CITY OF ALBUQUERQUE

1. The Traffic Circulation Layout & Details sheet
2. Submit back to ABQ Plan under the same Transportation submittal.

BIKE RAIL

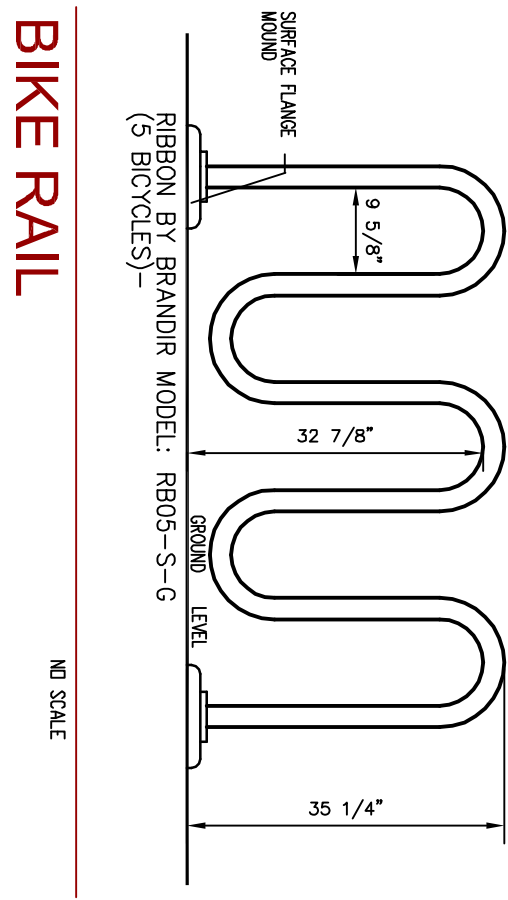
2. Bike rack spacing is required to be 4ft. inbetween racks. Also 2 bike racks is suficent to allow for 3 bicycle parking requirements can use 1 rack for 2 bikes.
3. Please remove the DFT sign off sheet.
